DECISION DELEGATED TO DEVELOPMENT MANAGER

Application No: H01-0452-21 **Applicant:** Mr & Mrs Cooper

Proposal: Erection of 3 dwellings - outline approval H01-0759-18. Also, modification of Condition 8 relating to visibility splays, in accordance with H01-1075-18.

Location: 68 Stone Gate Cowbit Spalding

Plan of Site showing Proposed Soakaways

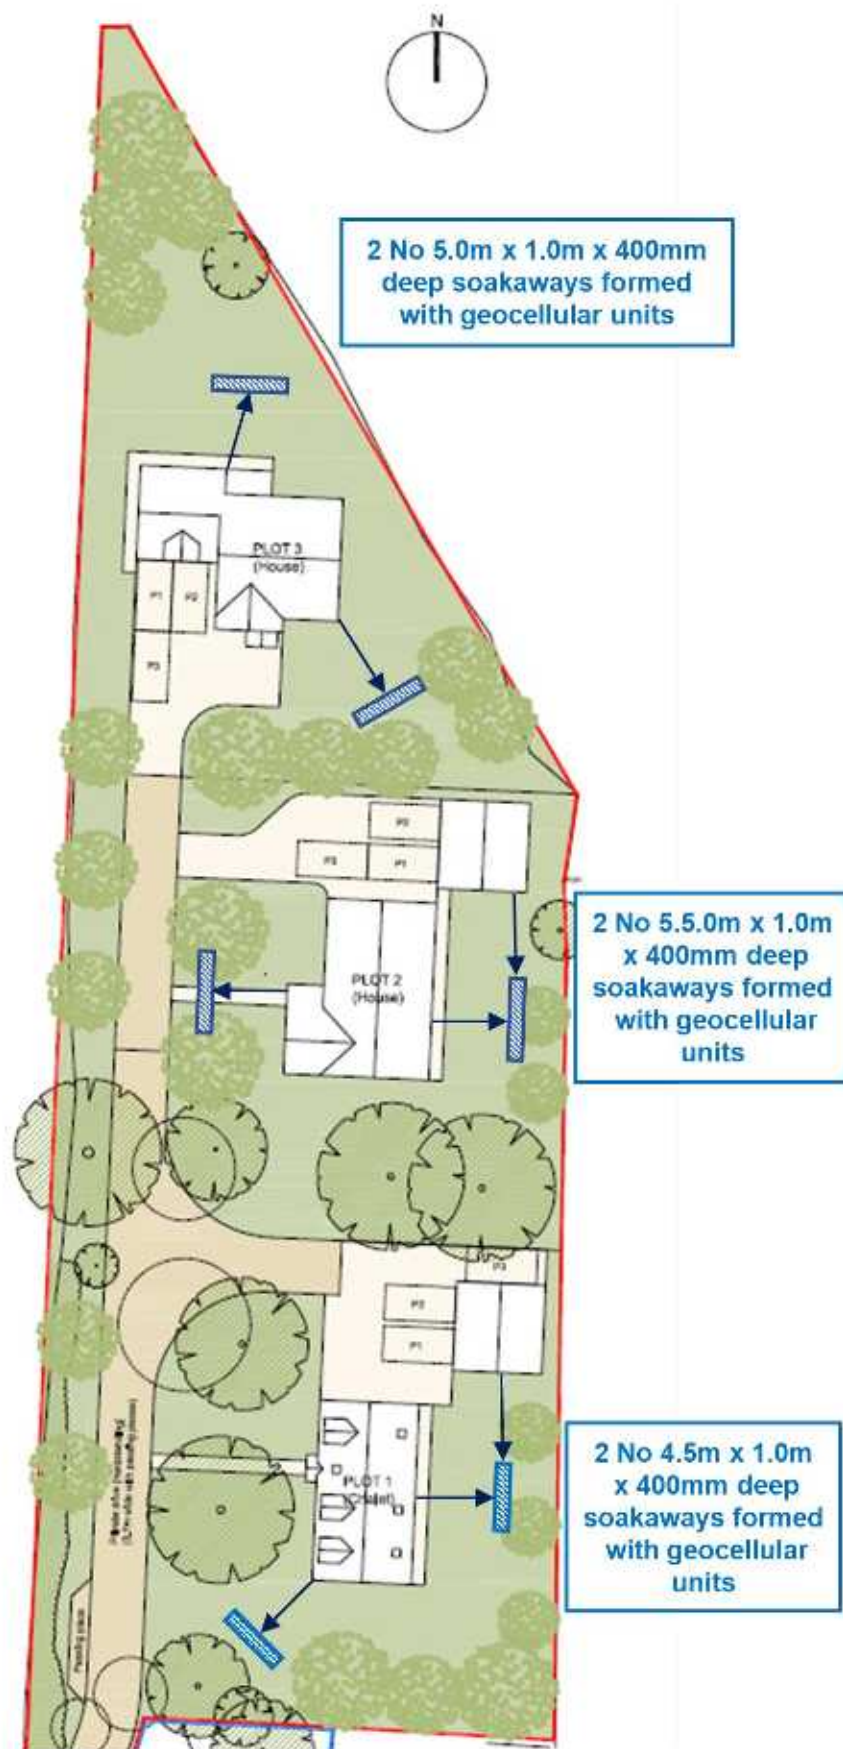
- However, on page 2 it is stated that groundwater was encountered at 1.3 m below ground level.

Under government guidelines there should be a minimum of 1.2 m between the base of any infiltration feature and seasonally high groundwater levels. I appreciate that as stated on page 5 the applicant intends to raise the ground level so that there is 600 mm of space in between the base of the soakaways and the groundwater level, however this still does not meet government guidelines. Furthermore, this infiltration testing was carried out during the summer, when groundwater levels are at their lowest; during the winter groundwater levels are likely to be much higher, possibly making the soakaways totally ineffective.

- Recommend that the Local Planning Authority satisfies themselves that infiltration is a viable method of surface water disposal at this site. If a strategy reliant of infiltration is not considered viable, the Board would be pleased to receive an application to discharge surface water to one of the riparian watercourses adjacent to the site boundary. This requires land drainage consent in line with the Board's byelaws (specifically byelaw 3) and any consent granted will likely be conditional, pending the payment of a Surface Water Development Contribution fee, calculated in line with the Board's charging policy.

Surface Water Drainage is to be dealt with by a system of soakaways and permeable paving. The response of the IDB set out above is noted. If it transpires that the Surface Water Drainage cannot be dealt with by the submitted scheme, then a further formal application would be required to discharge this detail. An informative is added to this recommendation to express this in the decision notice.

CONTRACT
SITE LINES PLAN

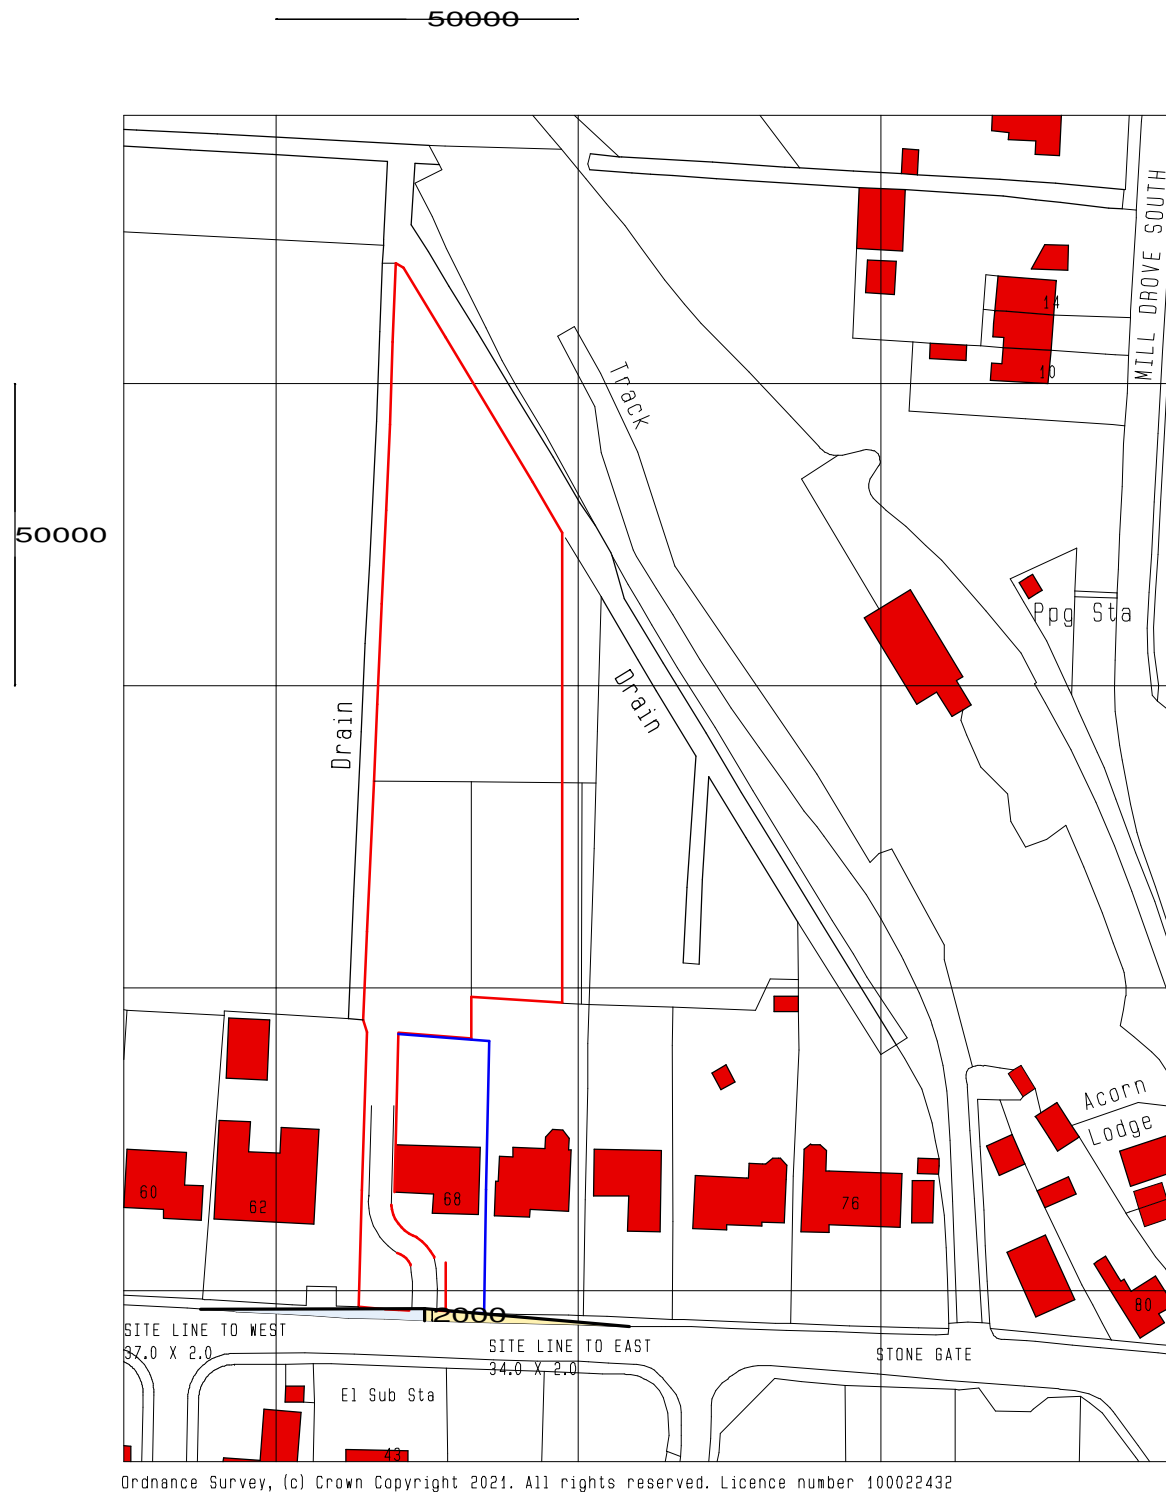
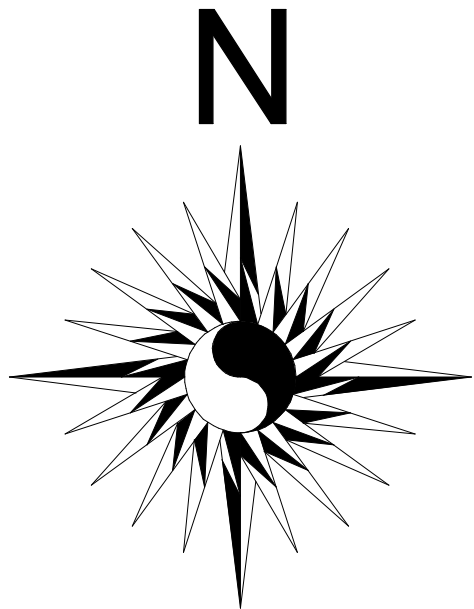
Ask the Applicant/Agent to amend the drawing to show the visibility splays required by the Outline Consent.

OFFICER NOTE - the S73 application above amended the outline condition.

The details of the S73 submission referenced above have been assessed by LCC Highways officers again and no objection was raised to the reduction of the vision splays for this site. The plans and details show sight lines to 2.0m x 37m (to the west) and 2.0m x 34m (to the east), as agreed by the S73 application (H01-1075-18 refers).
